16 March 2013

Re: Council Submission by Pitt St Resident

Objections to Environmental Assessment for a Project Application at the Former Rachel Forster Hospital Site, 134-144 Pitt St, Redfern (MP09_0068)

1 UPPER BASEMENT FLOOR PLAN
SCALE 1:200

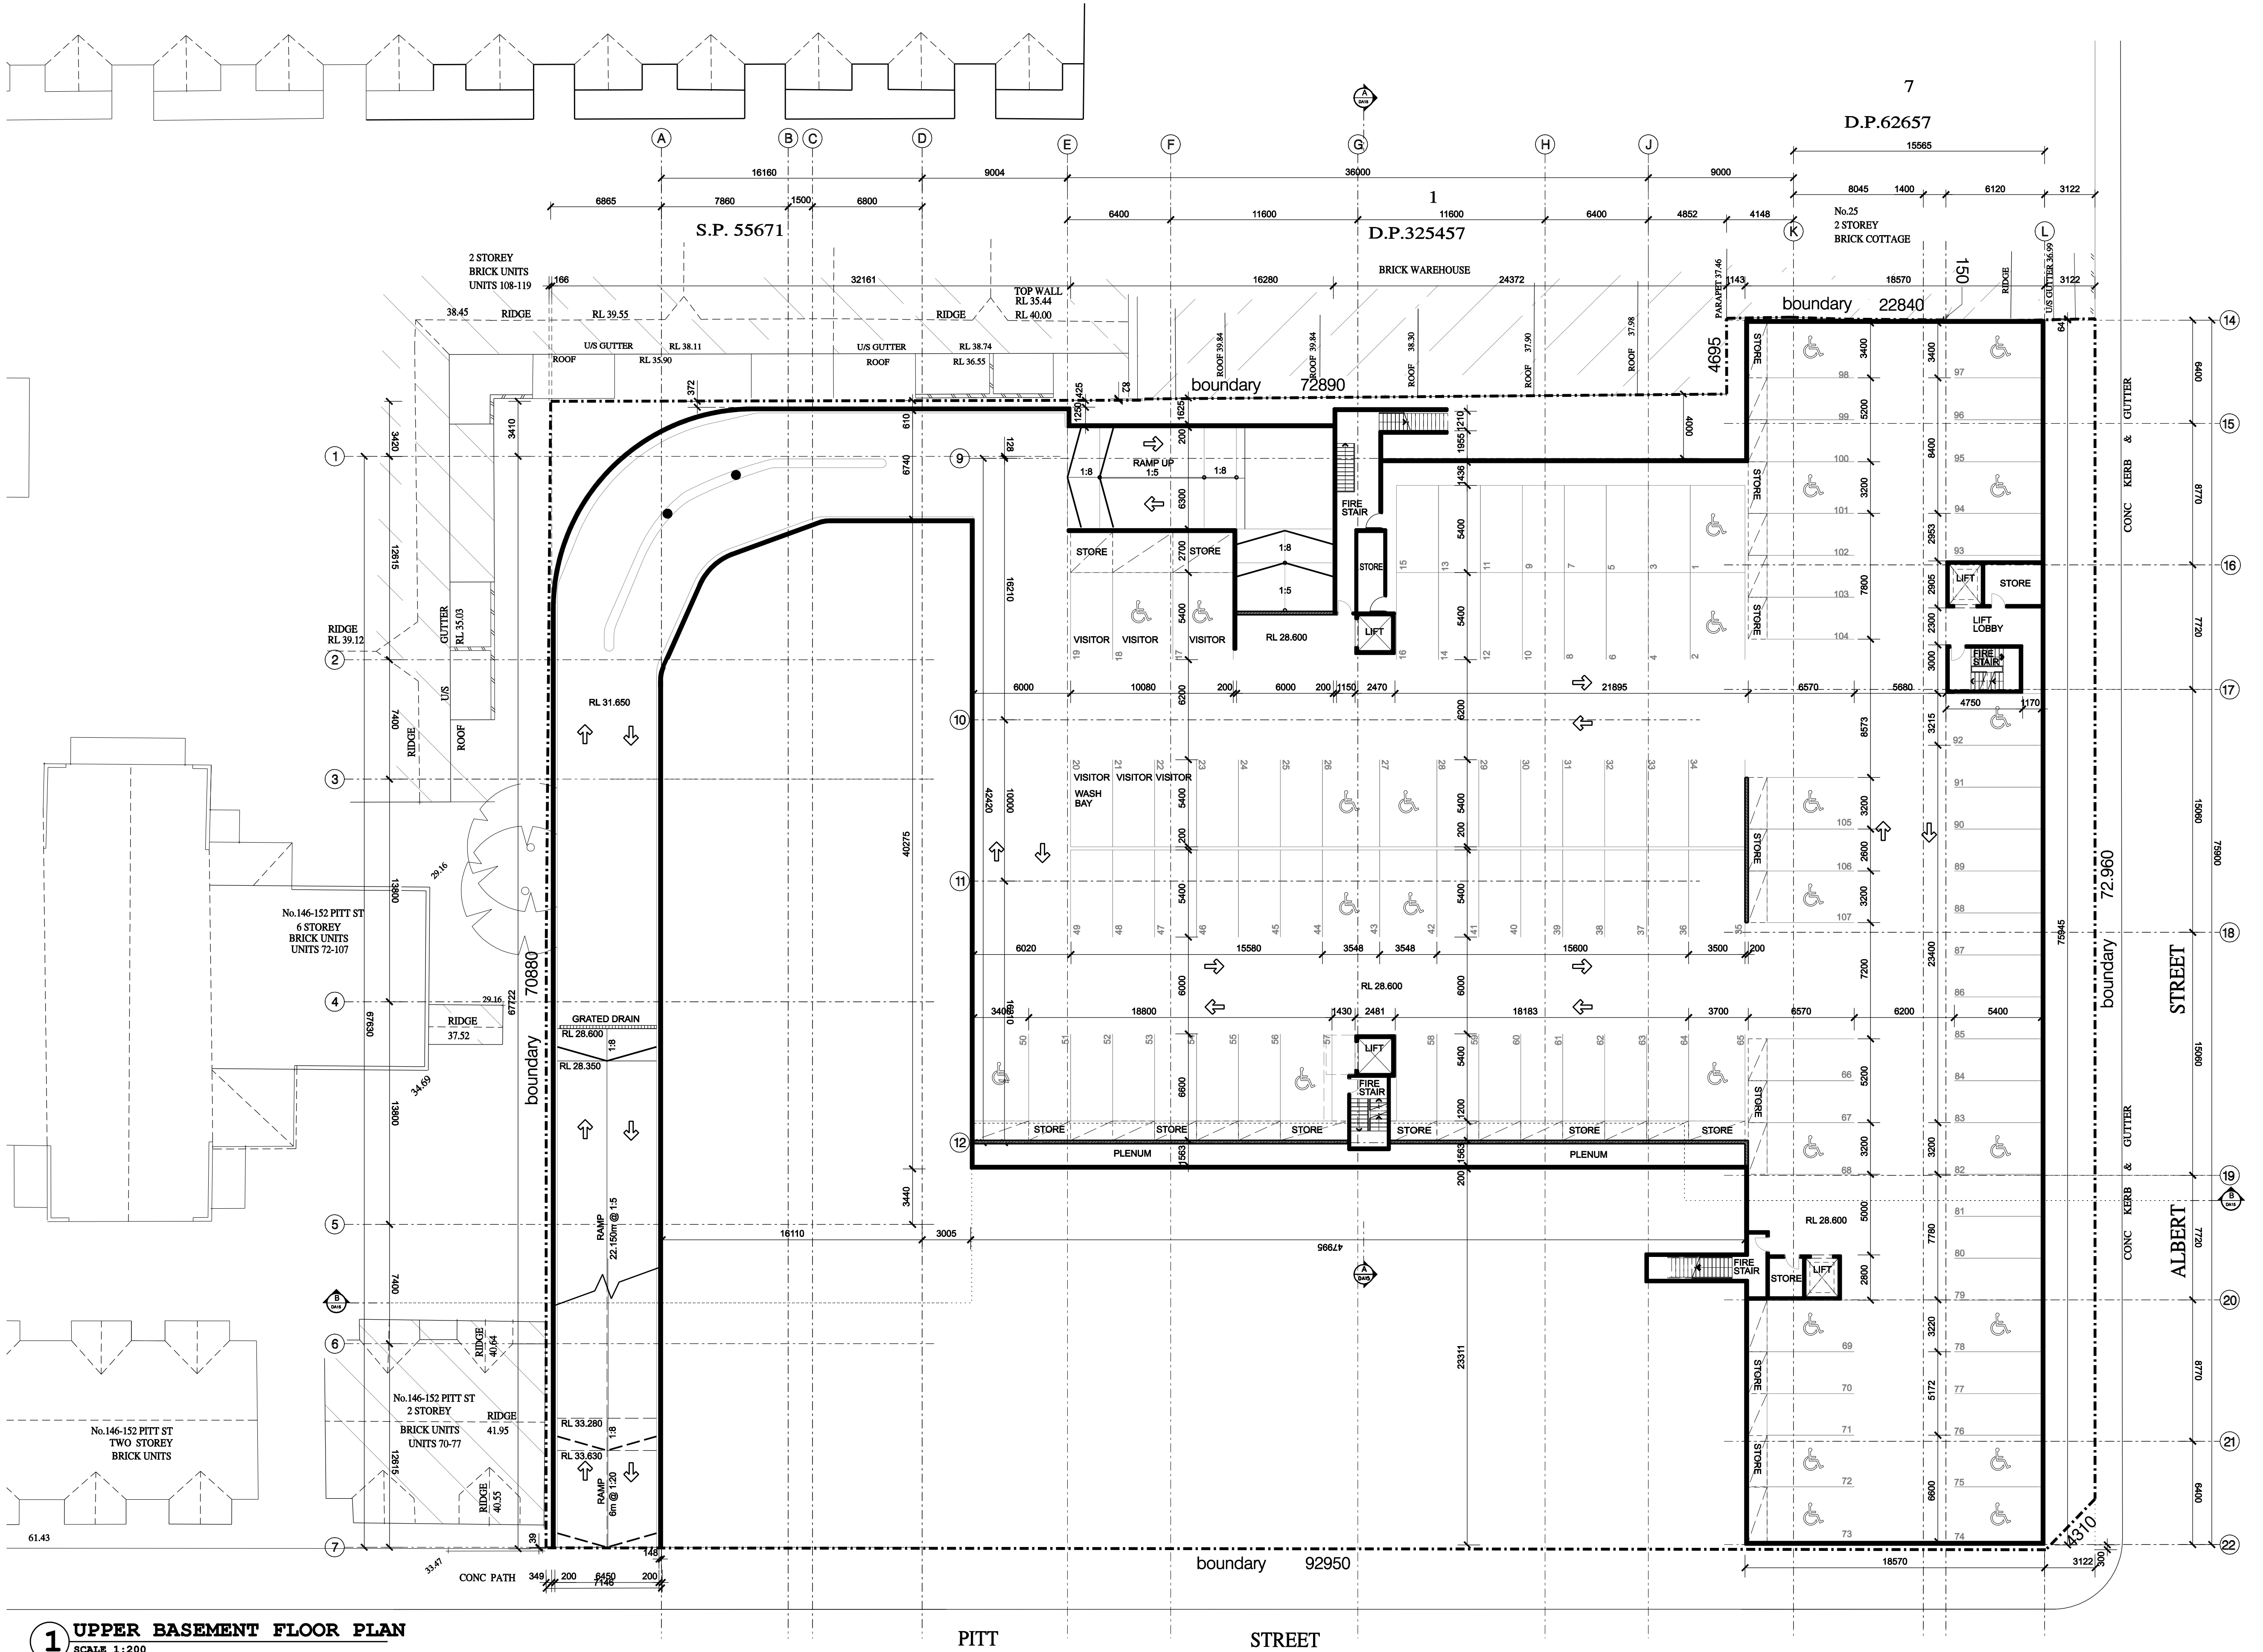
The number of apartments proposed for Building 3 seems out of keeping with the amenity of Albert St, which is already very narrow and primarily made up of 2 storey terrace houses (and 1 storey heritage item on the corner of Albert and Pitt Sts) directly adjacent. In particular the density of the Eastern frontage of Building 3 and the general loss of amenity for new residents to the complex living well below ground level seems a sub-optimal design approach. Visual privacy and acoustic privacy for Albert Street residents both in the new complex and adjacent will almost certainly be a problem given the proposed density, the inclusion of below-ground living spaces, and “high glazing to floor ratios”.

This design appears to attempt to squeeze the maximum number of apartments and people in, with little care for residential amenity or design best practice, in this case. Perhaps the basement spaces could be better put to use as gym, or common areas of some kind, and restricting residence to ground level and above. Or perhaps dual level townhomes could better incorporate the basement living areas as an alternative. I note that direct pedestrian access from Albert St was a modification sought with the original concept plan and I see no attempt at addressing the issue in this proposal. I also note that the elevator shafts rise significantly above approved ridge heights.

***ACTION SOUGHT:** reduction of the density of Building 3; provision of direct access for residents of the new development from Albert St; and improvement in the amenity for neighbouring terraces and buildings in Albert St.*

LANDSCAPE PLAN

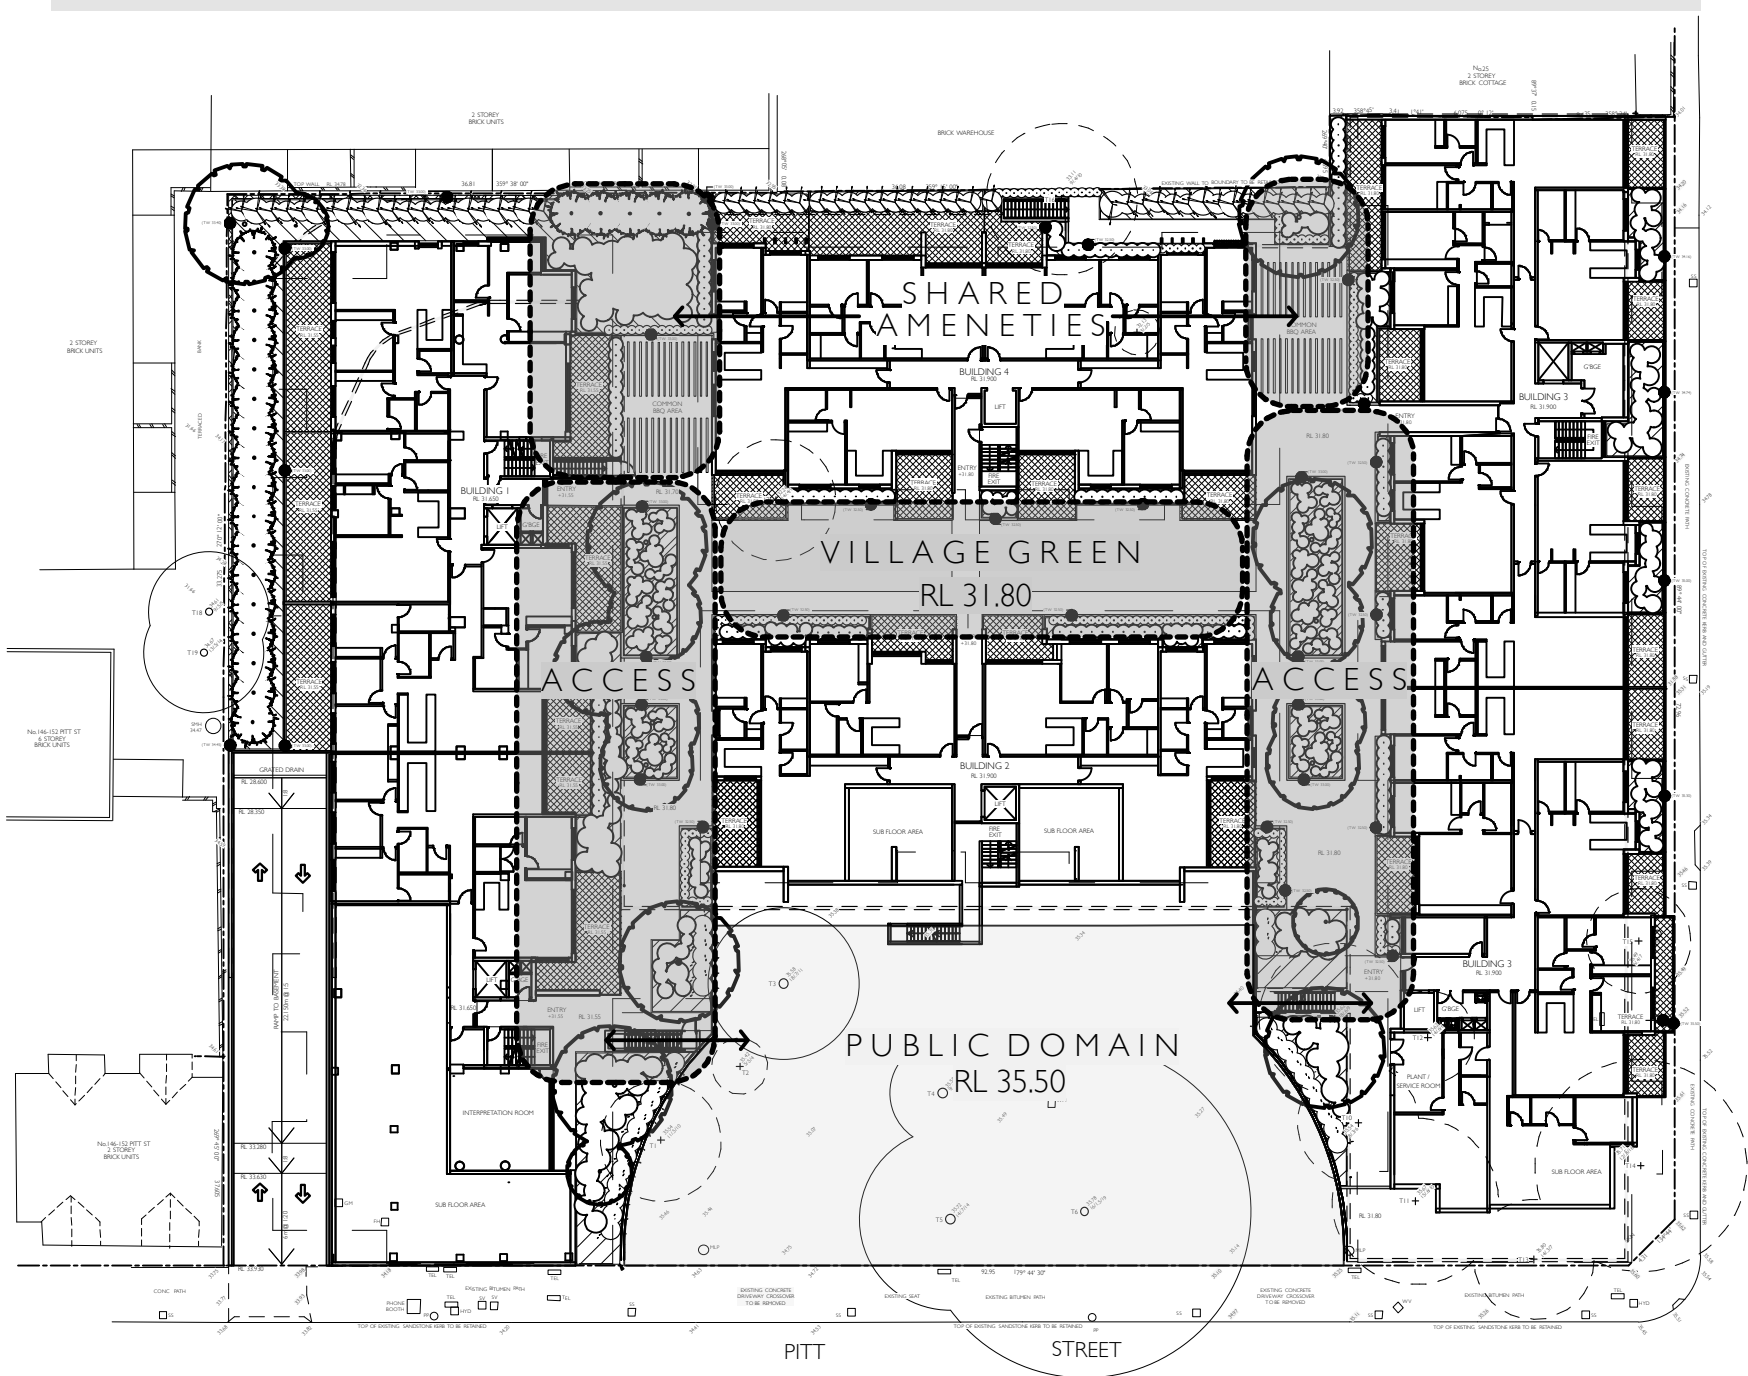
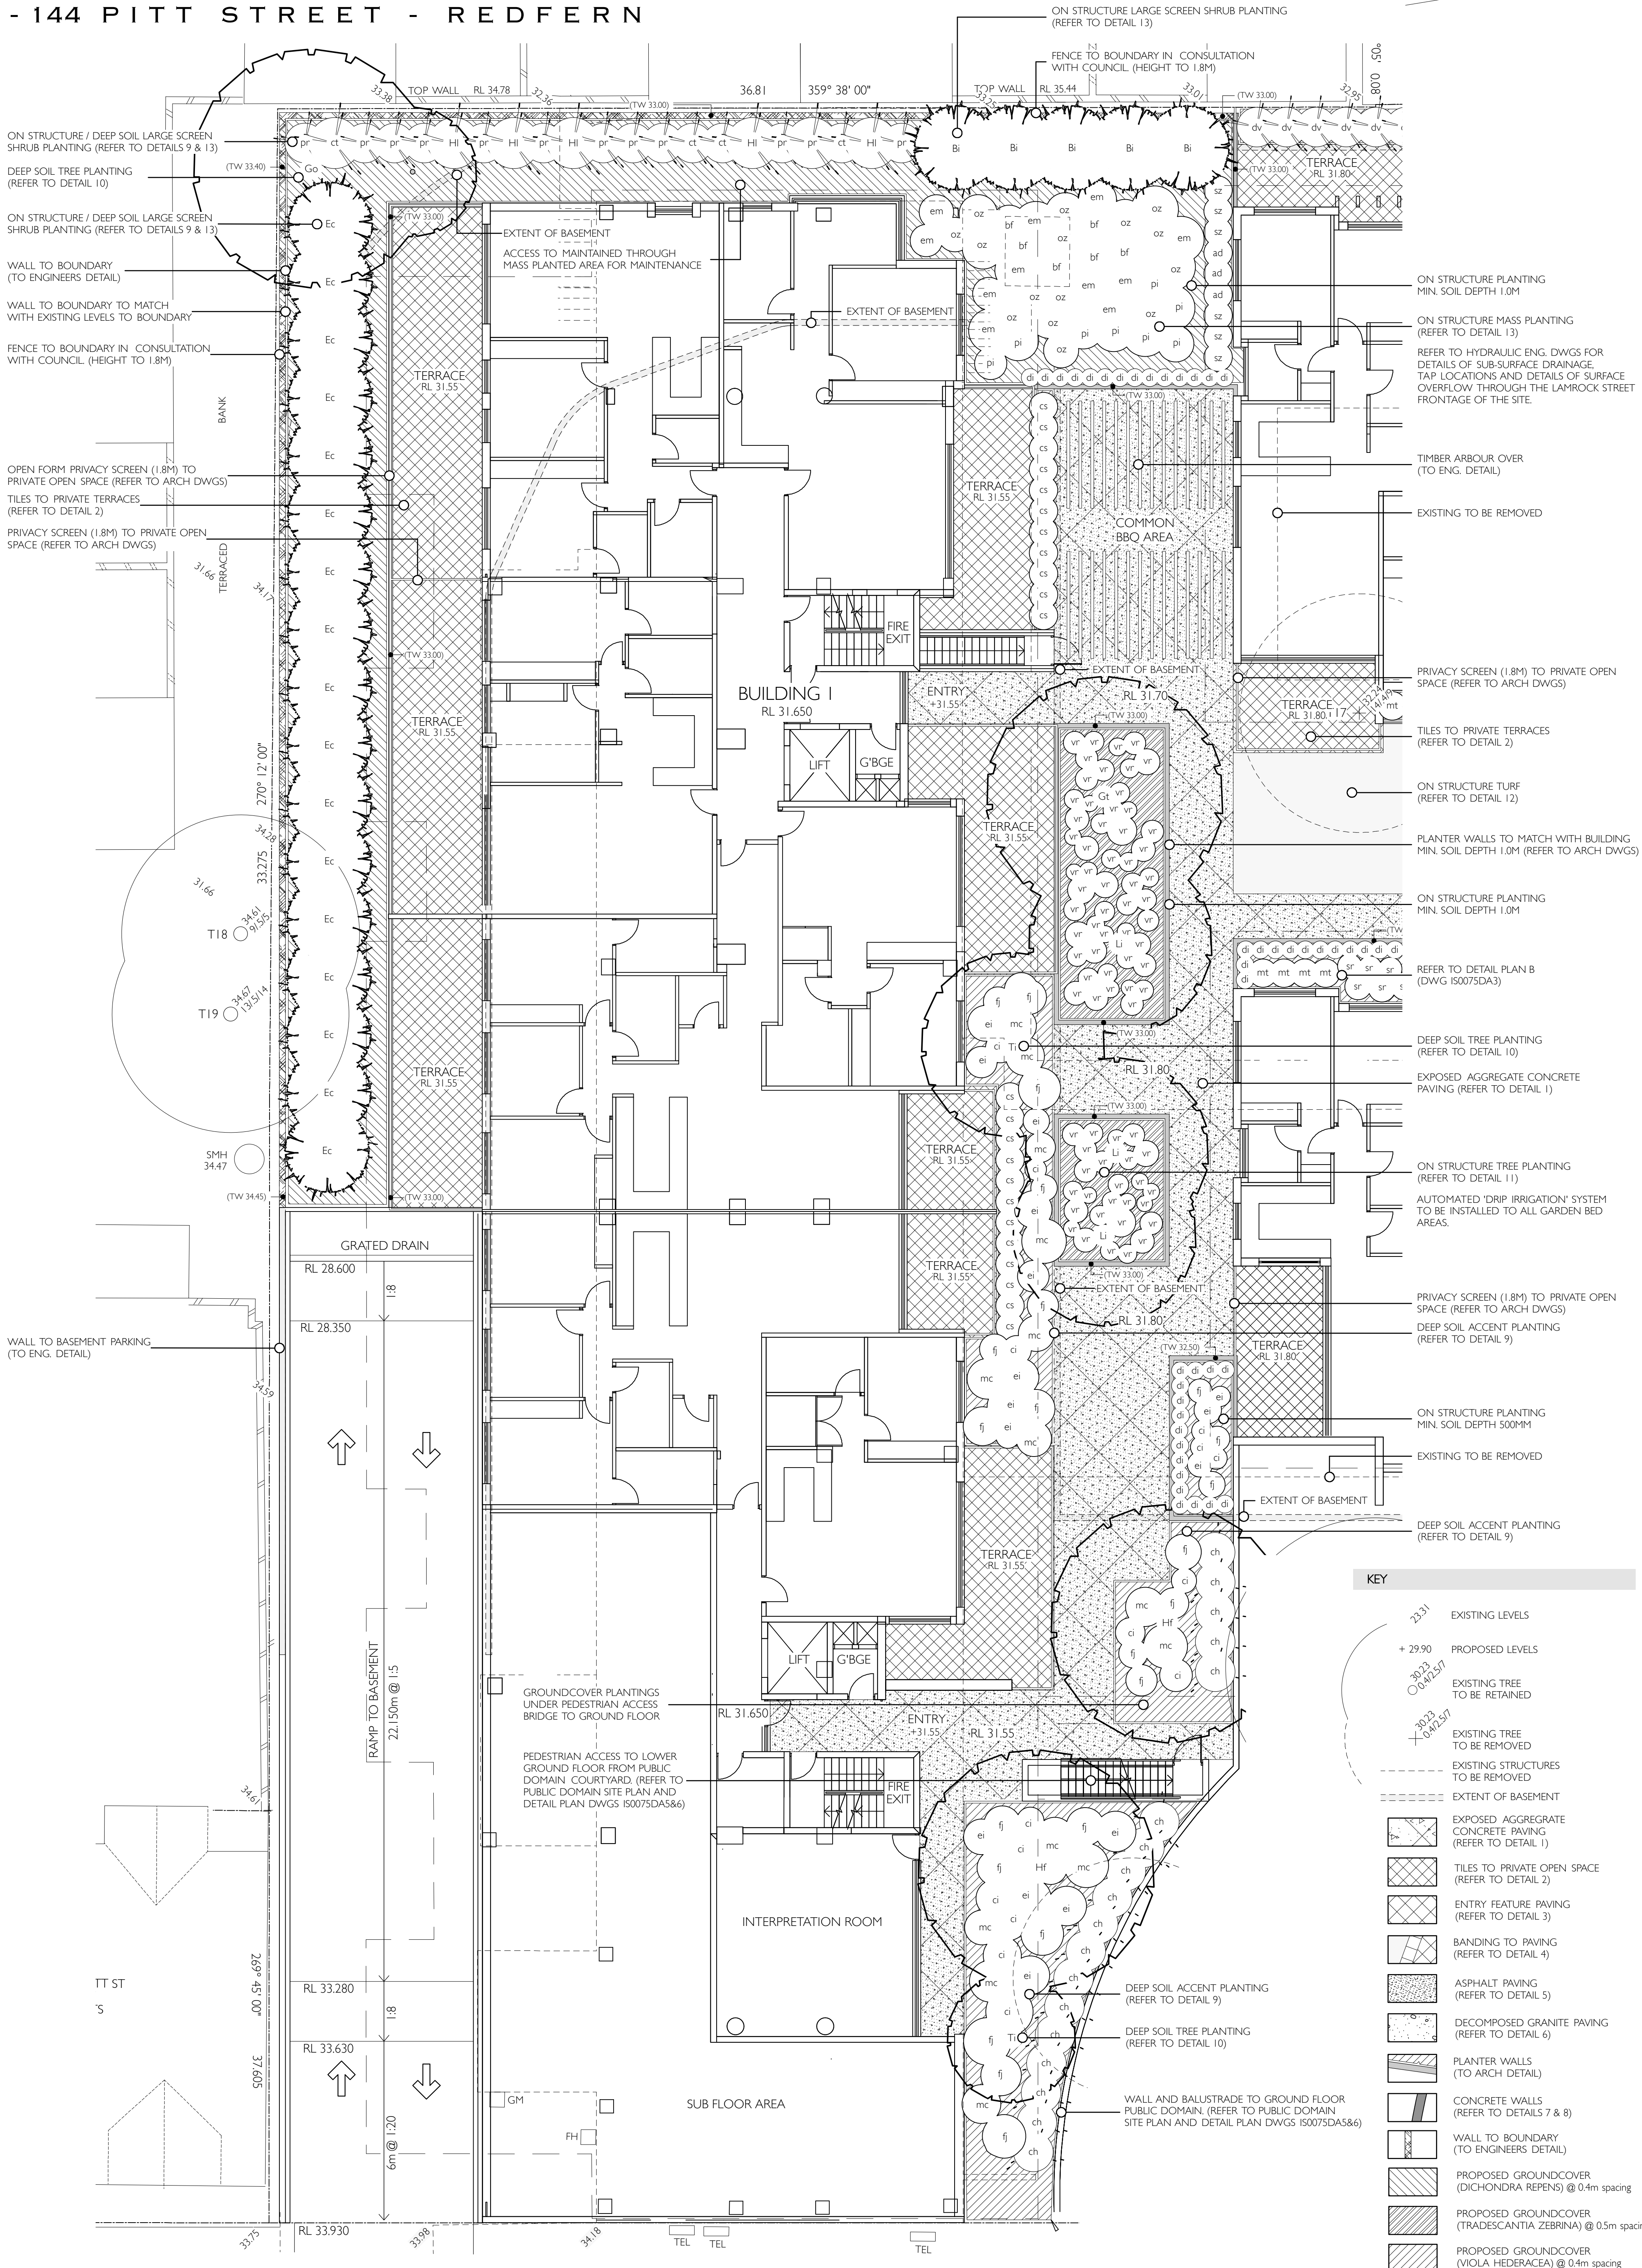
The original concept plan presented a public space with an area of 1,060m² (or 15% of site area) with 15 of 19 mature trees being slated for removal. With the new proposal, the public space has been reduced to 615m² (or 9% of site area), presumably to increase poor solar/acoustic amenity between Bldgs 2 & 3 proposed in the original concept plan. This represents a significant reduction in scale of the original commitment of the developer, and thus it will reduce neighbourhood and residential amenity. Perhaps as a compromise for this reduction in the public space commitment, the developer could be required contribute some common space in the form of childcare, for example, or contribute further to the funds for local infrastructure improvements.

***ACTION SOUGHT:** increased contribution to local infrastructure if public space commitment is reduced.*
